**Subject:** Stormwater Comments Color  
**Page Index:** 1  
**Date:** 5/11/2021 7:51:09 PM  
**Author:** CFurchak  
**Color:** ■  
**Layer:**  
**Space:**  
**Page Label:** [1] 1 CV01

GRADING EROSION CONTROL PLAN

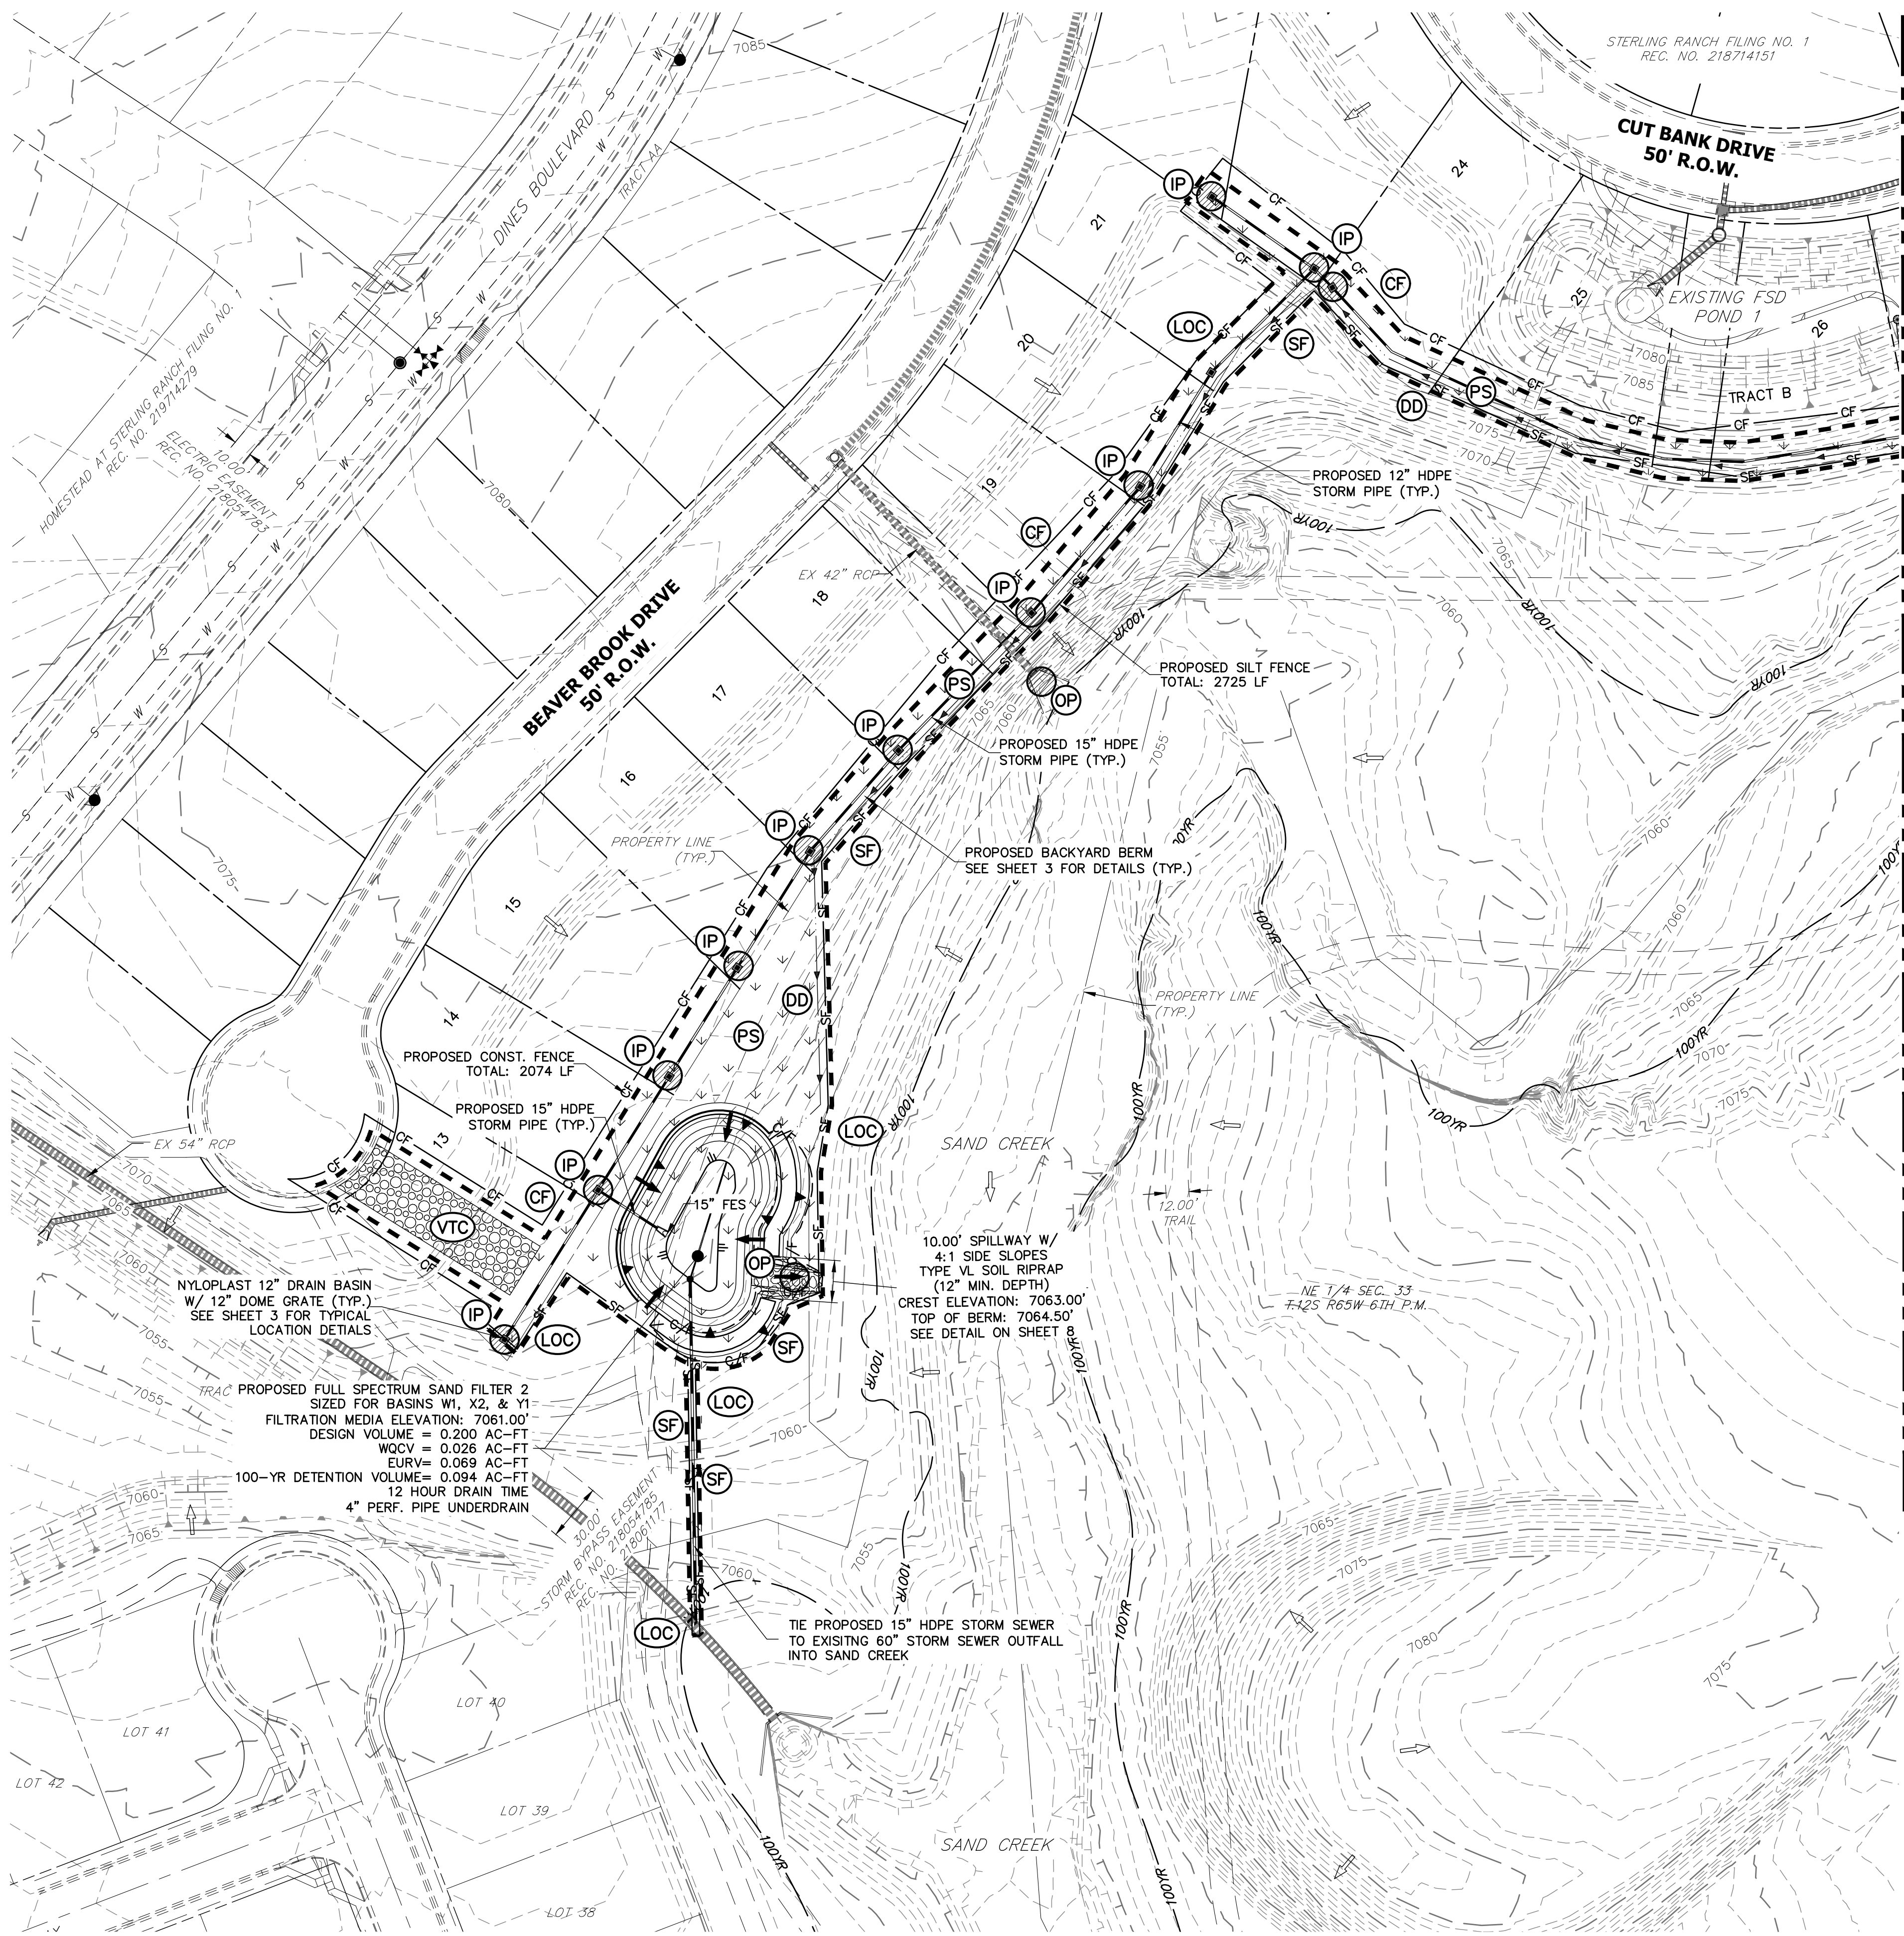
Berm along property line?

Move CWA next to street

berm

Add cross-section

Add at least one cross-section through each sediment filter basin

clearly show the extent of the berm and add to legend.

Add LOC line type to legend. If "limits of disturbance" and "construction boundary" are the same, change to "construction boundary/limits of disturbance" or otherwise show as separate linetypes for each on the legend and figure.

show extent of cut/fill  
 show construction boundaries and limits of disturbance.

label as VTC. Doesn't seem long enough. VTC should be 75' in length

Show locations and provide details of temporary sediment basin, including riser pipe perforation sizing, number of rows, required volume, and tributary area to the sediment basin.
